City of Albuquerque

August 10, 1990

RE: DRAINAGE PLAN FOR AN ADDITION TO MARTIN J. VIGIL BUILDING
(J-14/D91) ENGINEER'S STAMP DATED JULY 31, 1990

GRADING AND DRAINAGE PLAN
NEW BUILDING ADDITION FOR
MARTIN J. VIGIL
1315 SECOND STREET N.W.
ALBUQUERQUE, NEW MEXICO

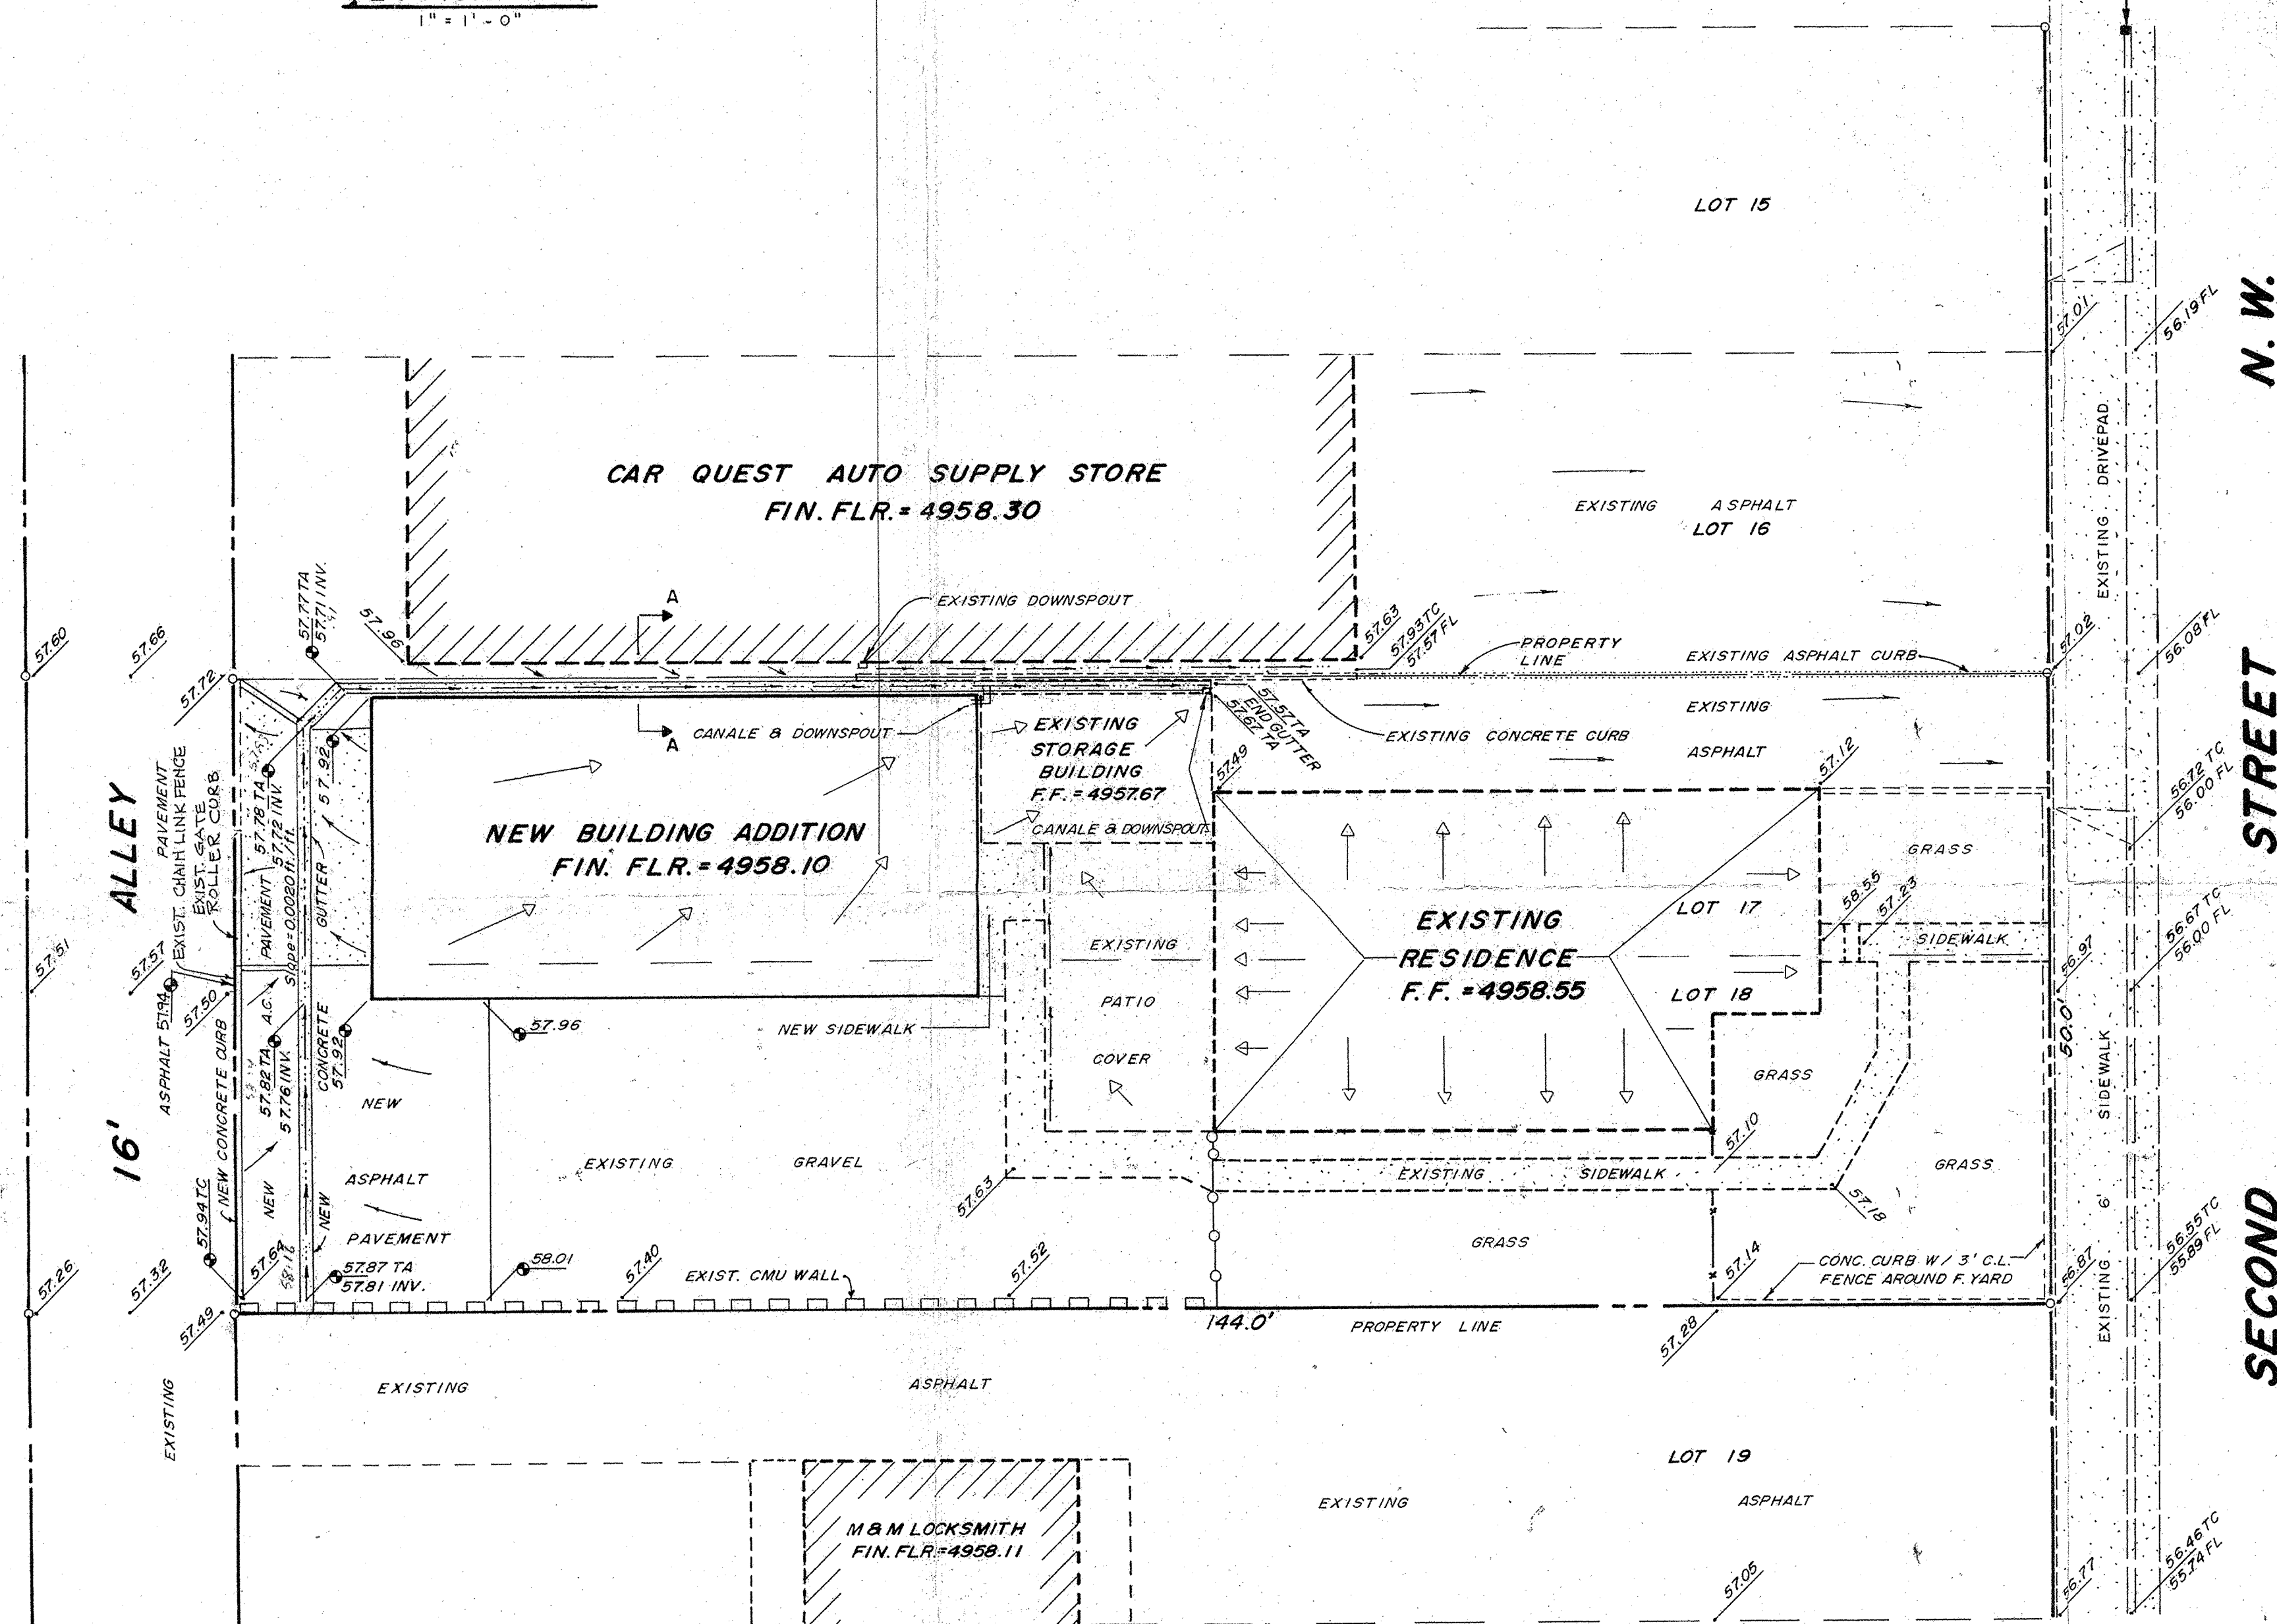
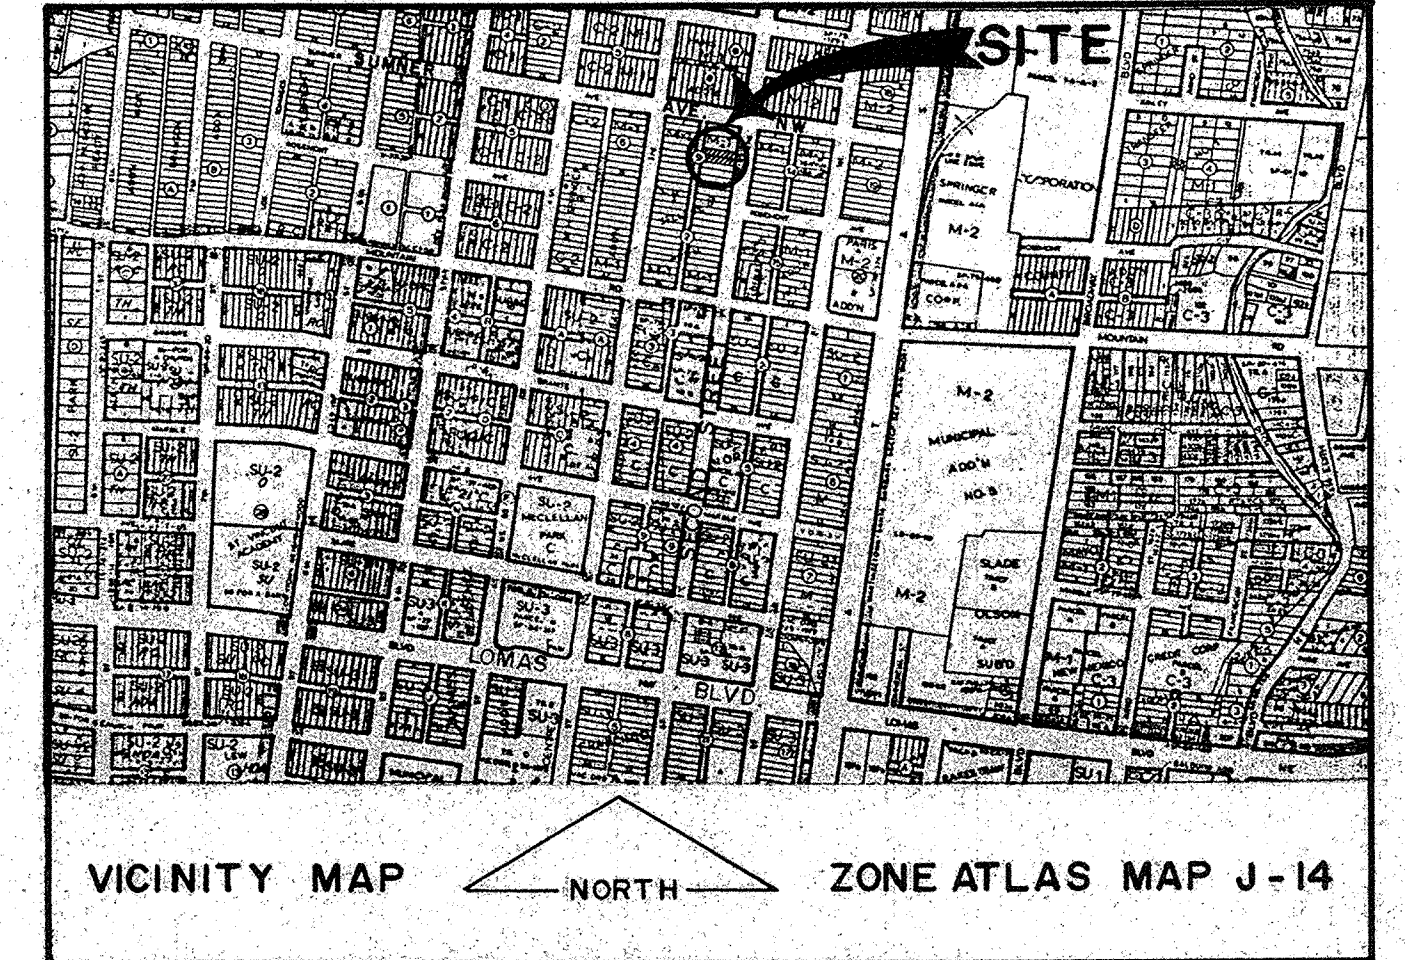
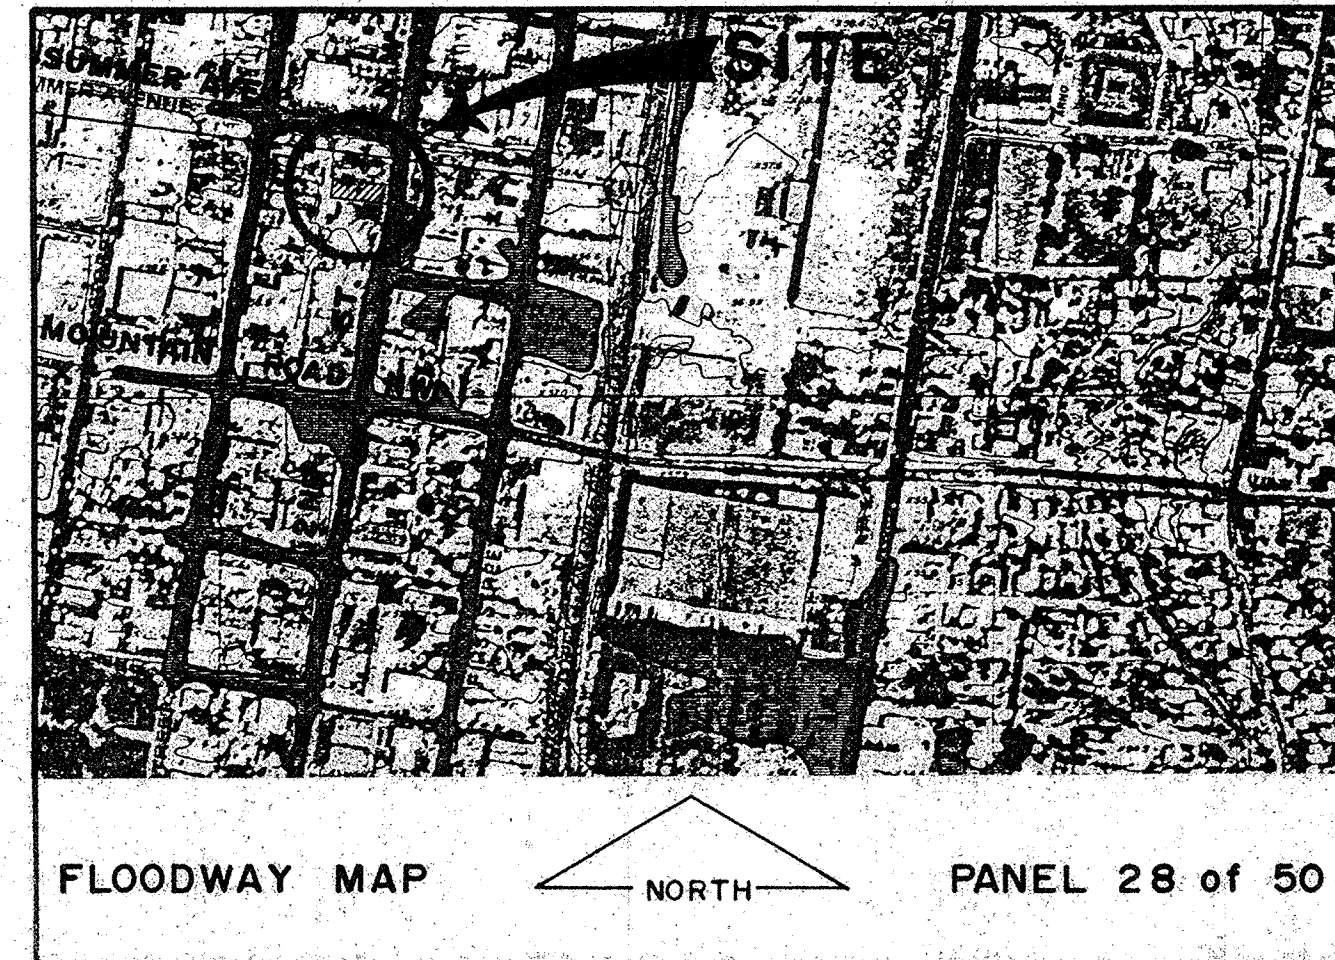
1. 0.002 ft/ft slope is not adequate to drain the runoff. A minimum of .5% slope is required.
2. If the alley is paved and you can demonstrate that it will carry the runoff toward the closest improved public street. Then you may want to design for this concept.
